Reference No: **2025/NM/93415/W**

Site Address: land at, Mount Pleasant, Plains Lane, Marsden,  
Huddersfield, HD7 6AN

**DECISION – NON MATERIAL AMENDMENT REFUSED**

## **Officer Report – 2025/93415**

Drawing Number:
37/2405/10

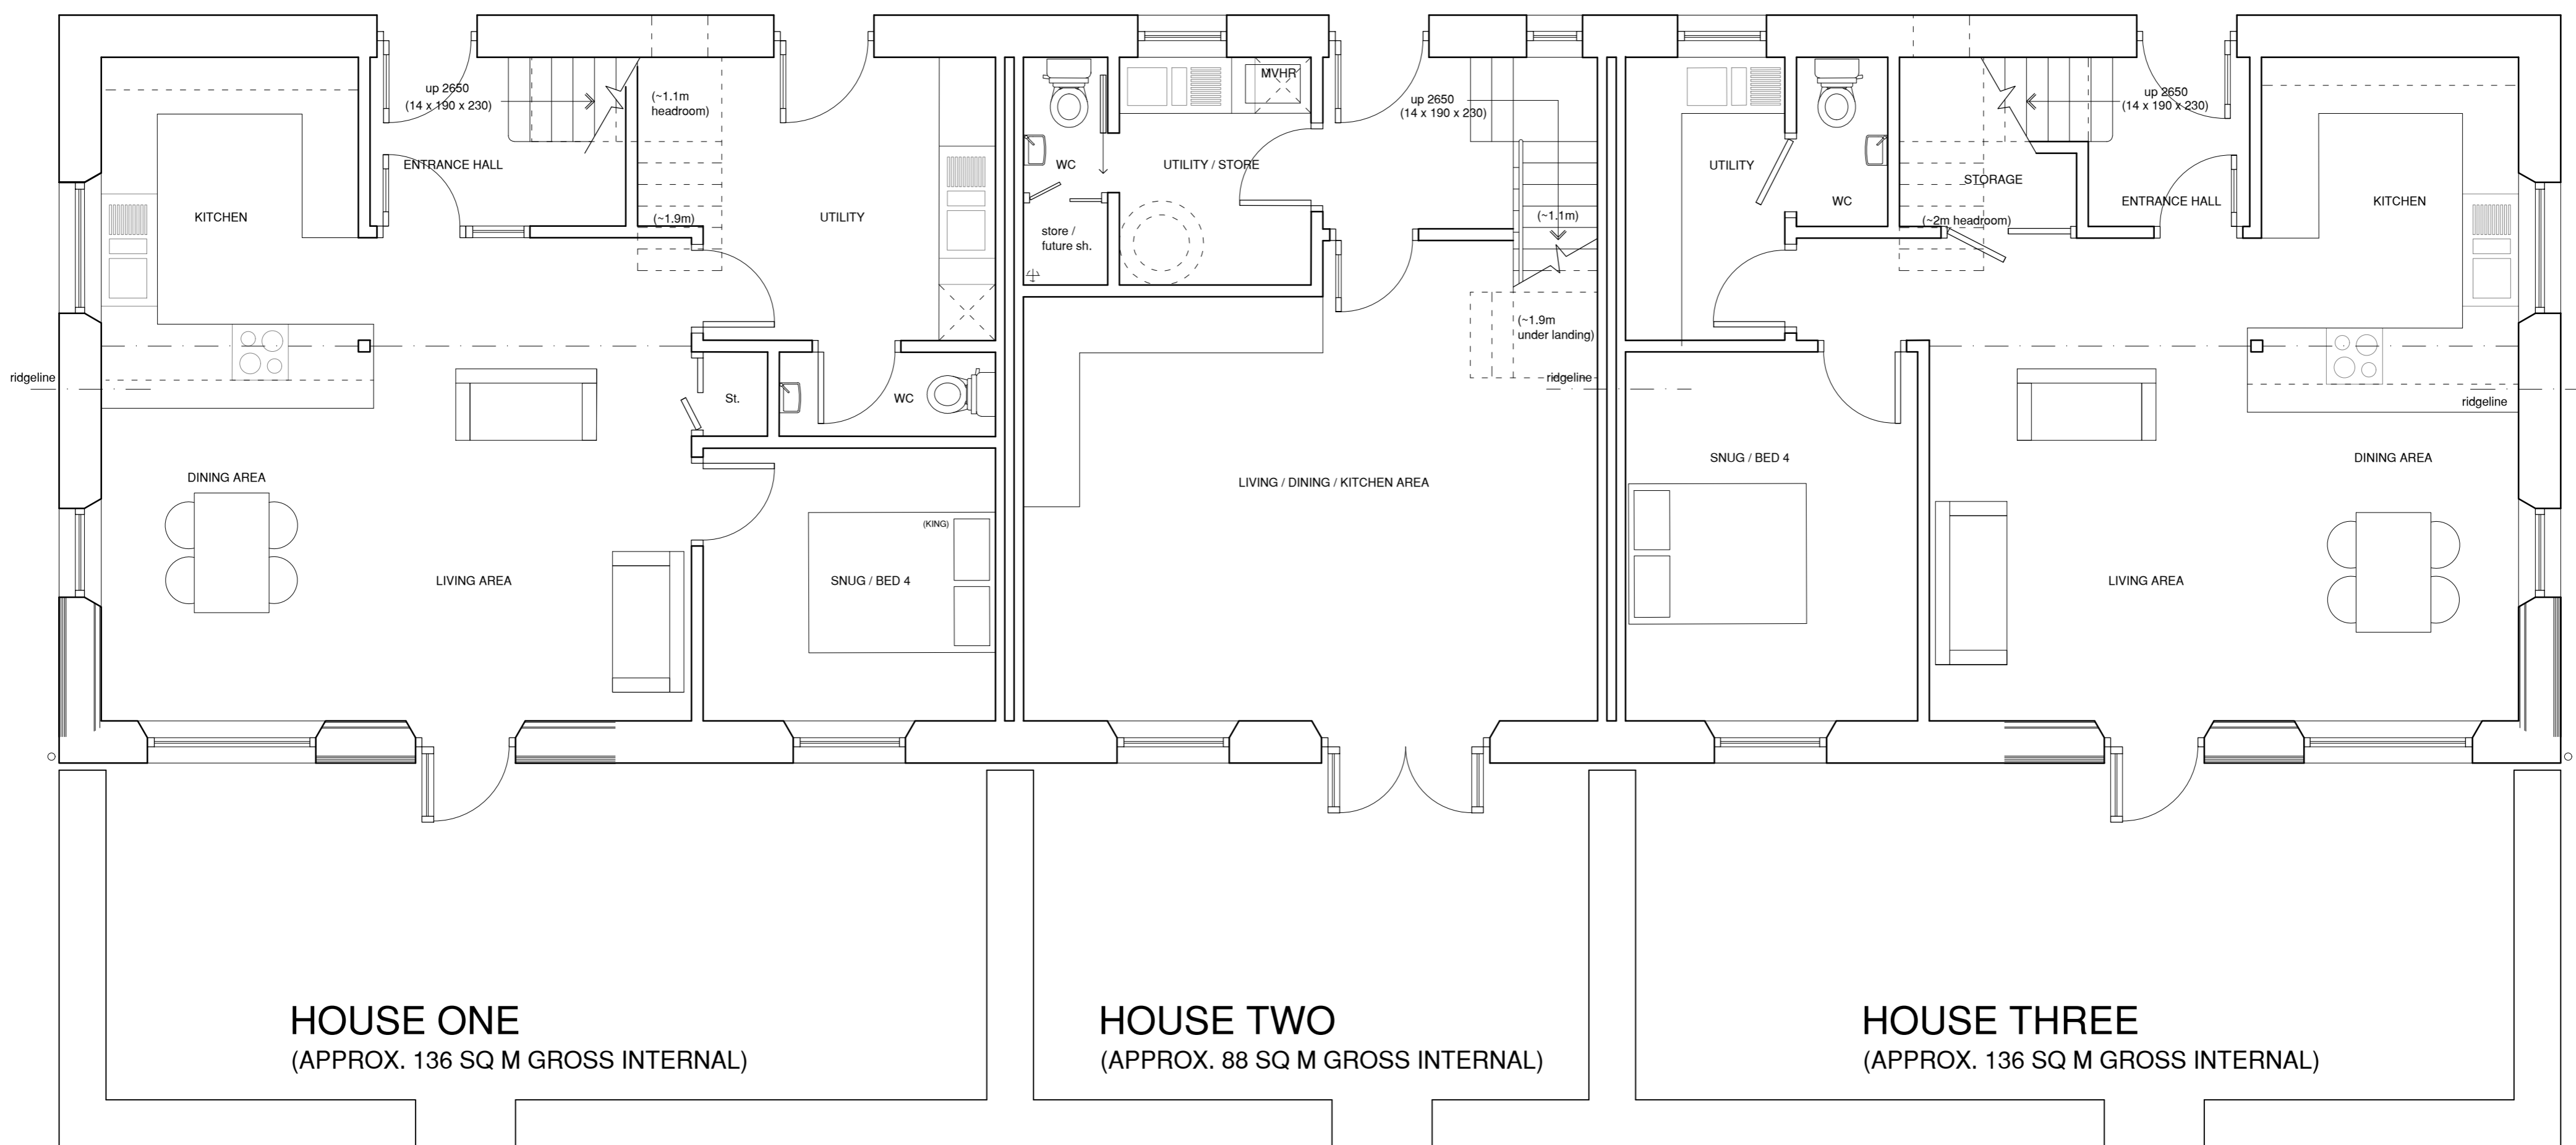
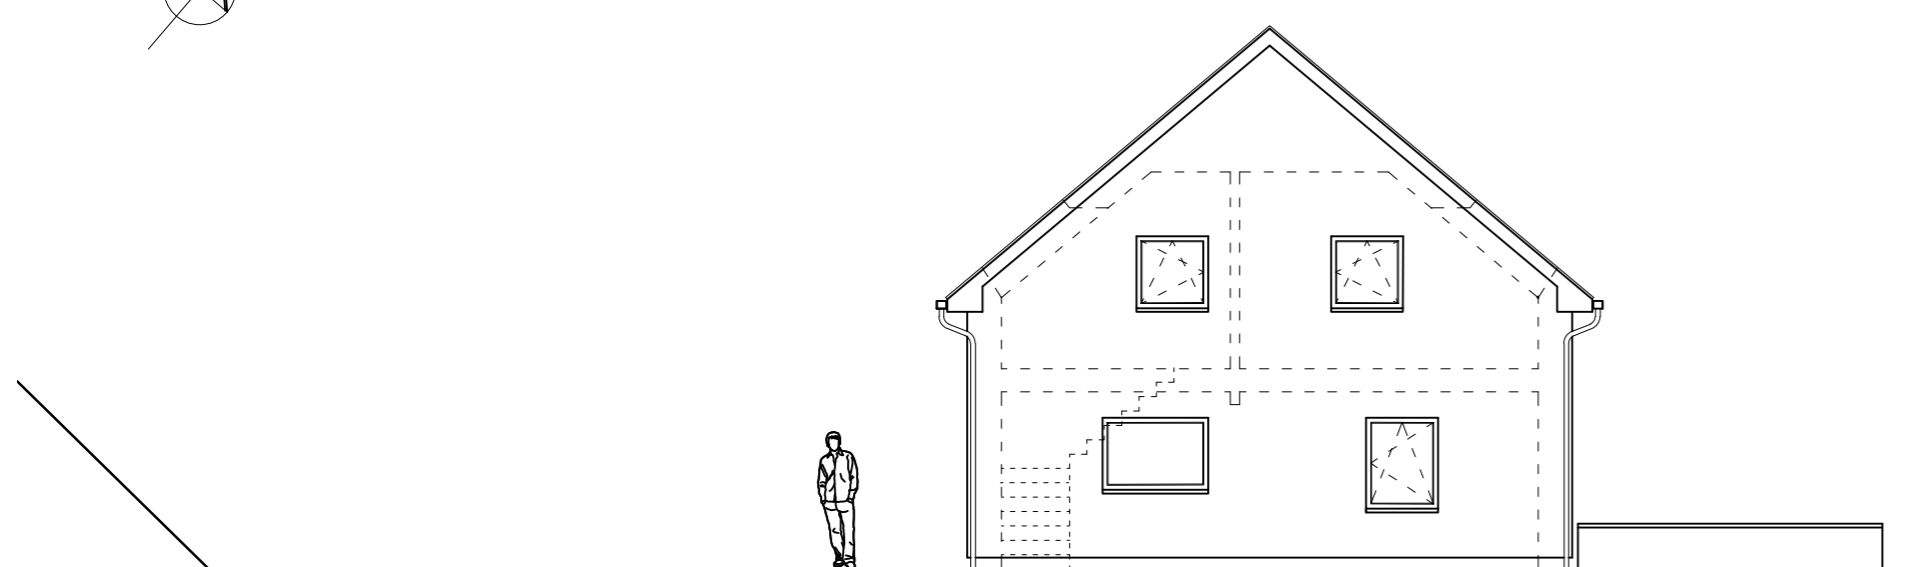
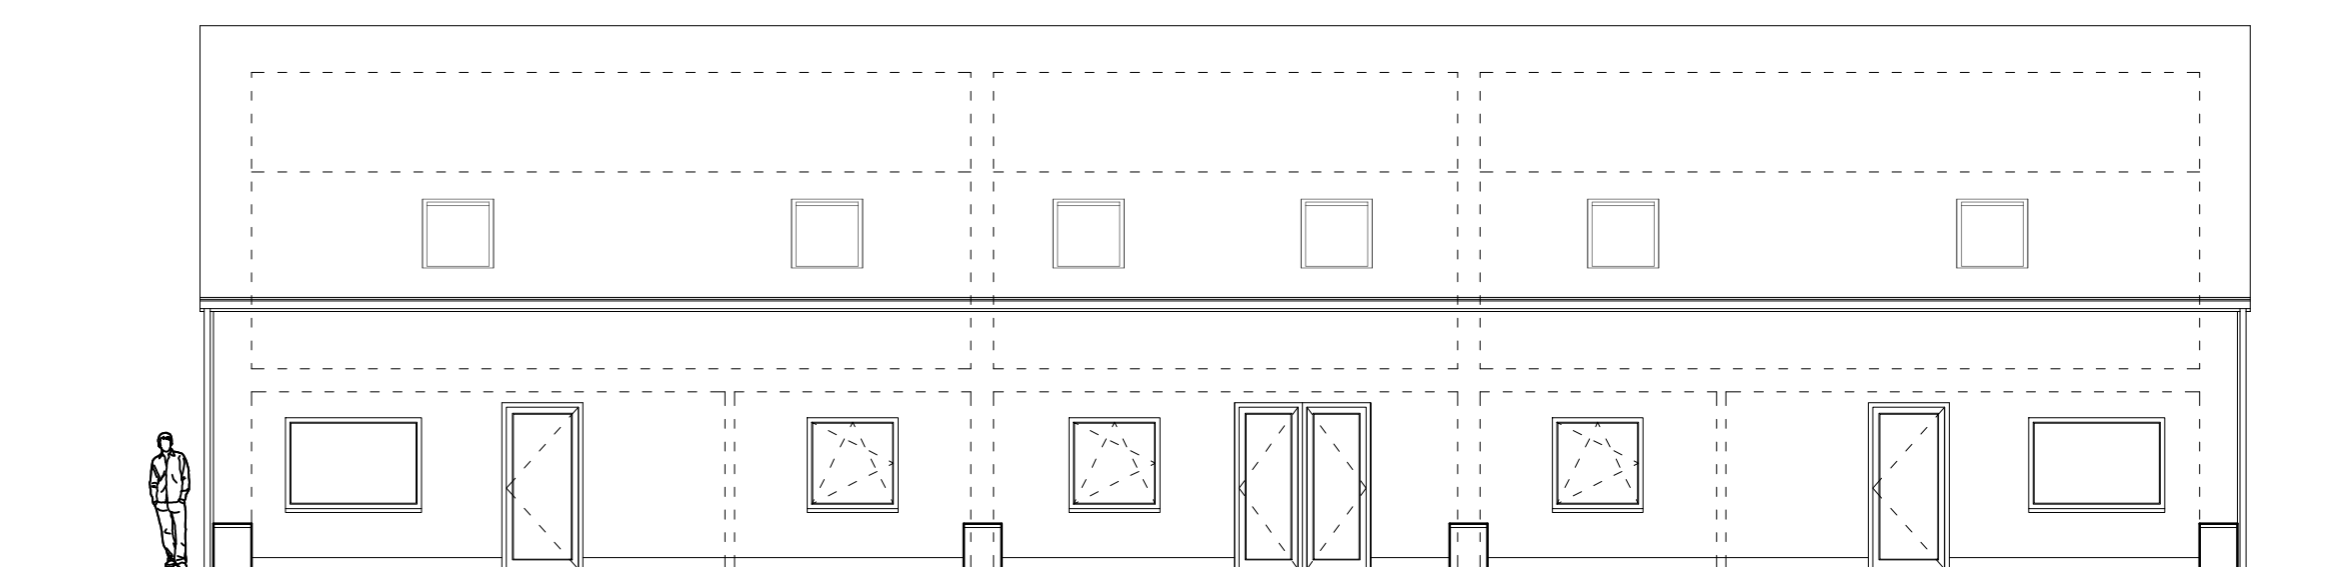
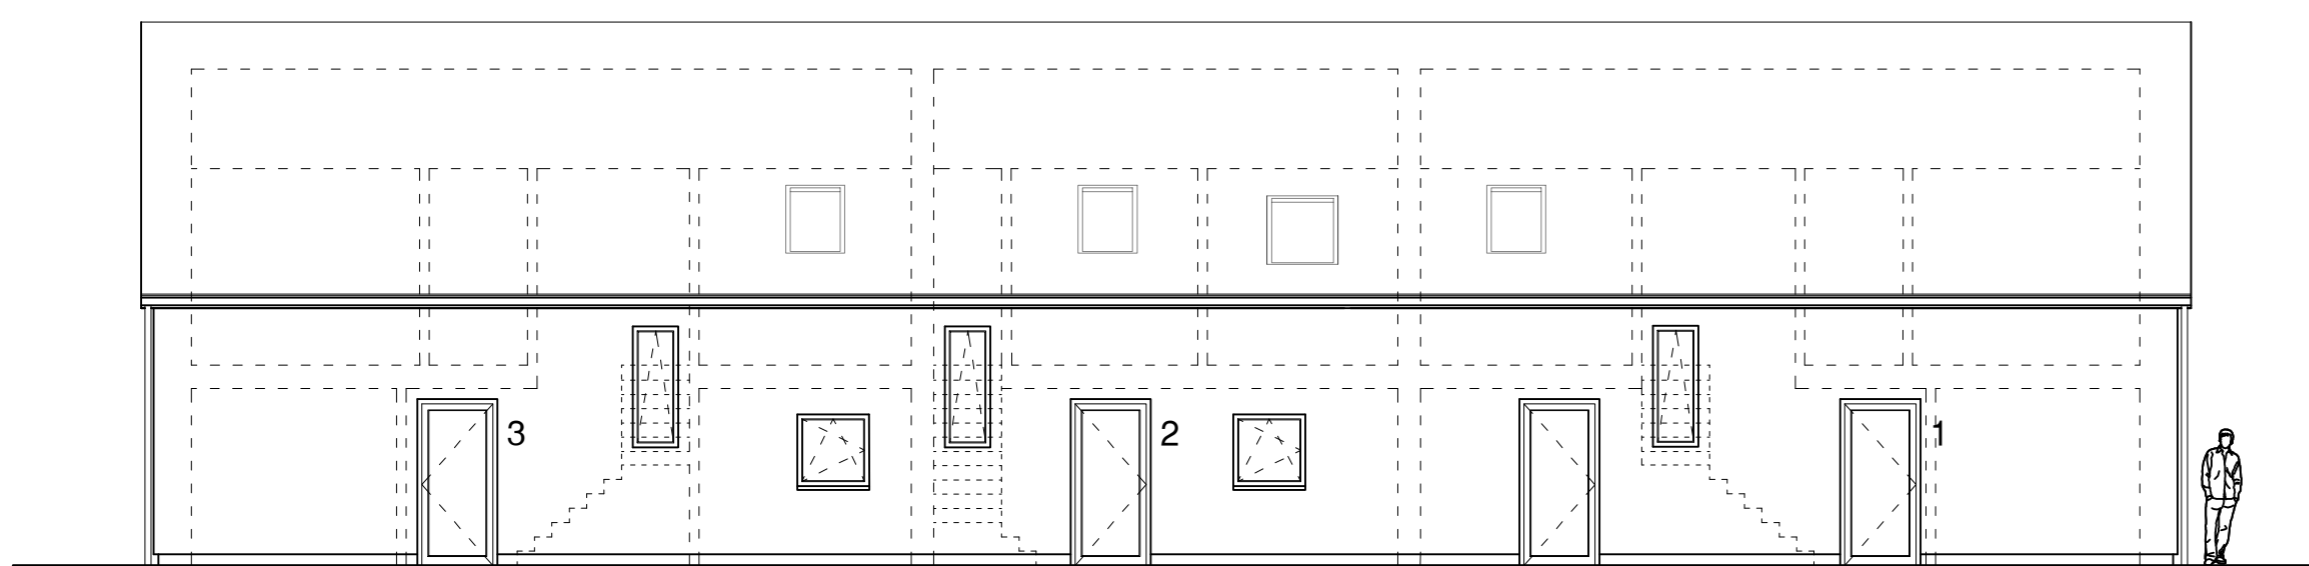
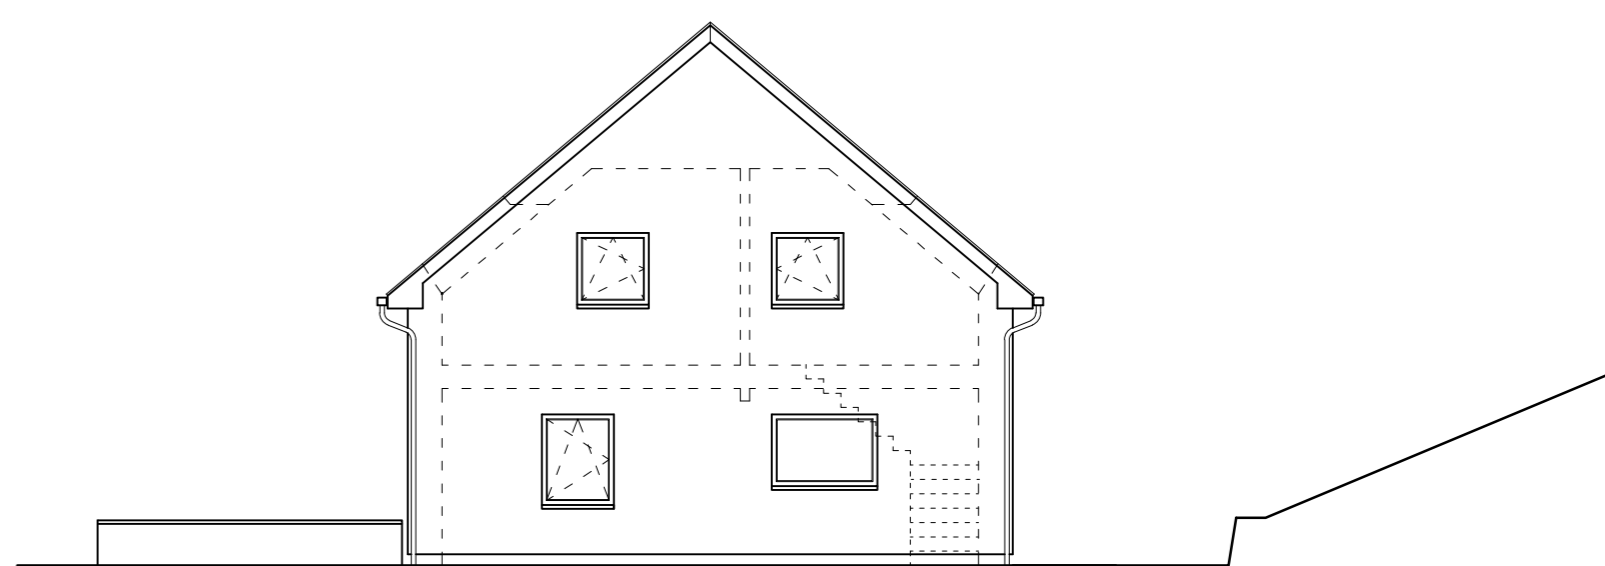
In this instance, the submitted amendments include alterations to window and door positions, the introduction of large rooflights, and the creation of additional habitable accommodation within the dwellings. In addition, the proposal seeks to increase the ridge height by approximately 403mm compared with the approved scheme.

These changes directly align with the categories of development identified within the Council's protocol as being unlikely to be accepted as non-material amendments, namely a material increase in the height of the building. Furthermore, the internal reconfiguration resulting in additional bedrooms (House 1 and House 3) materially alters the functional form and typology of the approved dwellings and the scheme would require assessment of the impact in terms of the amenity of future occupiers.

Whilst the proposed alterations to external openings, roof detailing and larger roof lights across the roof would be acceptable in isolation, in terms of visual and neighbouring amenity impacts. The overall quantum of the development is considered to fall outside the scope of that which can be considered a non material amendment in this case.

Accordingly, the proposal falls outside the scope of what can reasonably be regarded as non-material within the meaning of Section 96A of the Town and Country Planning Act 1990.

The amendments shown on drawing No 37/2405/10 are not considered appropriate to be regarded as a non-material amendment to the previous planning approval (reference 2024/93046).
